STURTON BY STOW PARISH COUNCIL

COTTAM – DEADLINE 1 SUBMISSION

SCALE: NTS	DATE: 14/12/22	DRAWN: AC	CHECKED: RR	APPROVED: JD
JOB NO: 2107-062		DRAWING NO: Figure 4.3		REVISION: -

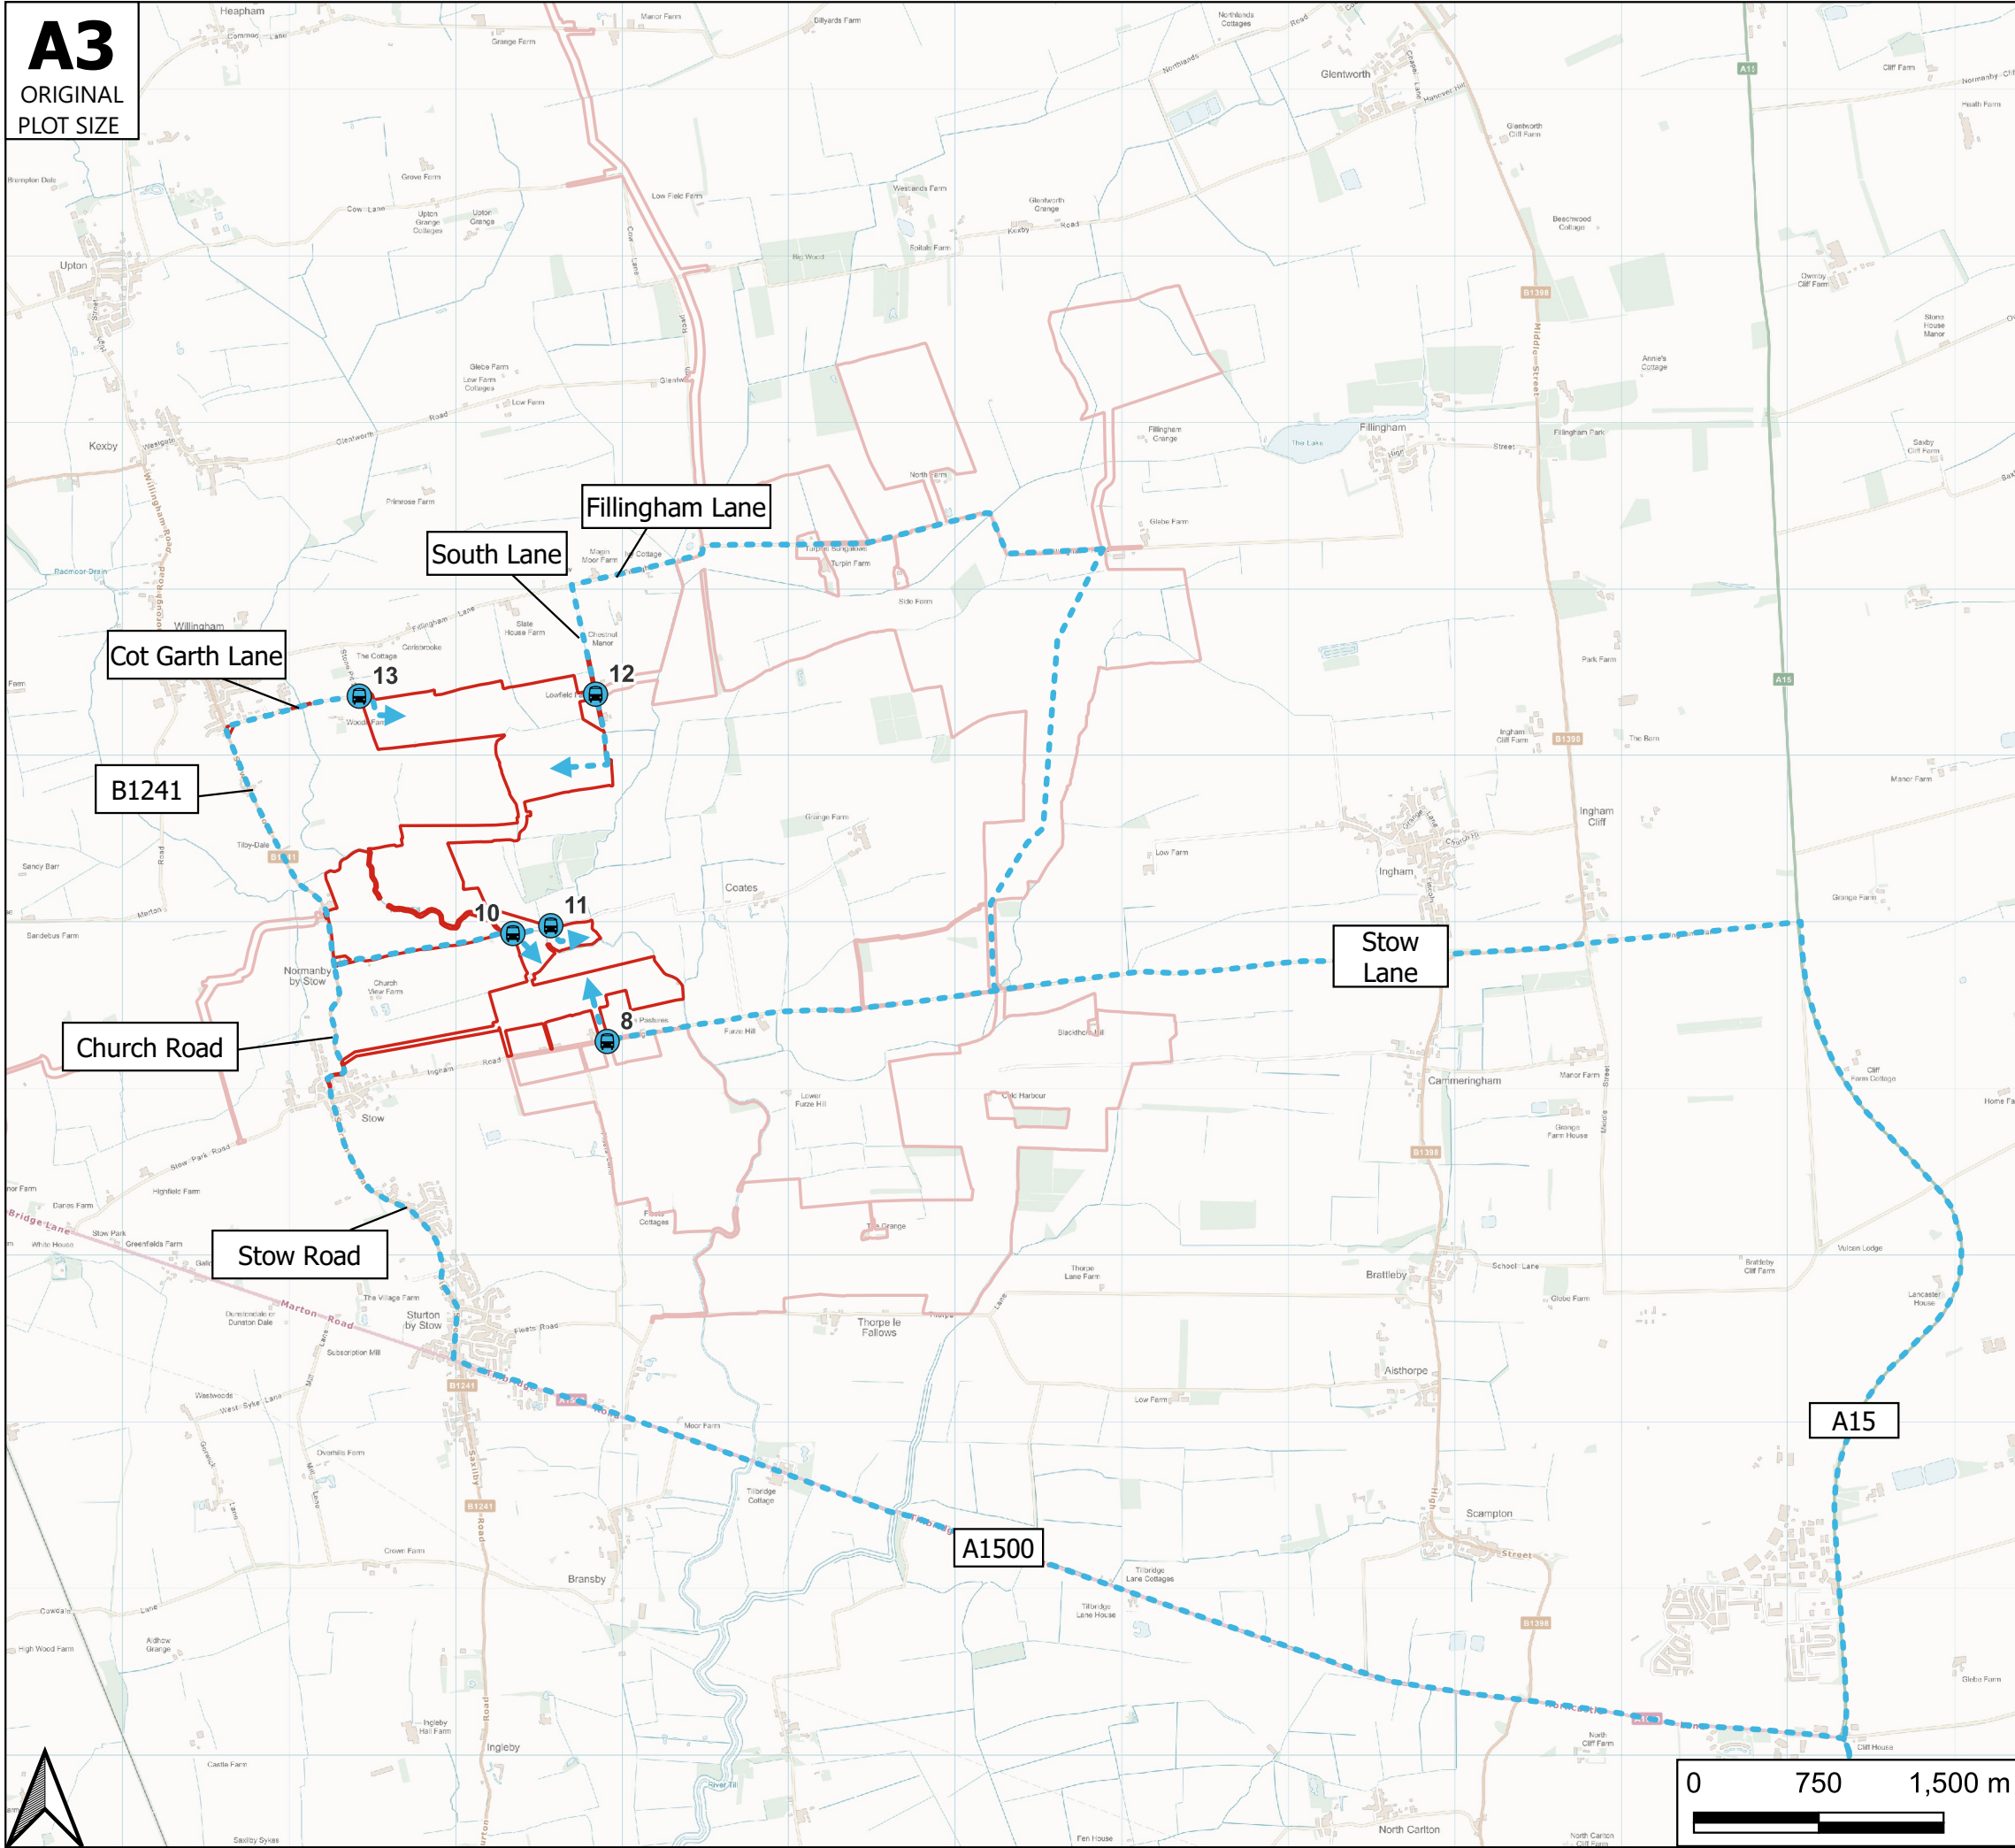
Drawing number Figure 4.3 incorrectly labels High Street (B1241 at Sturton by Stow) as Stow Road. This is High Street. Stow Road does not appear until after School Lane, Sturton by Stow.

Please correct the maps and route plans.
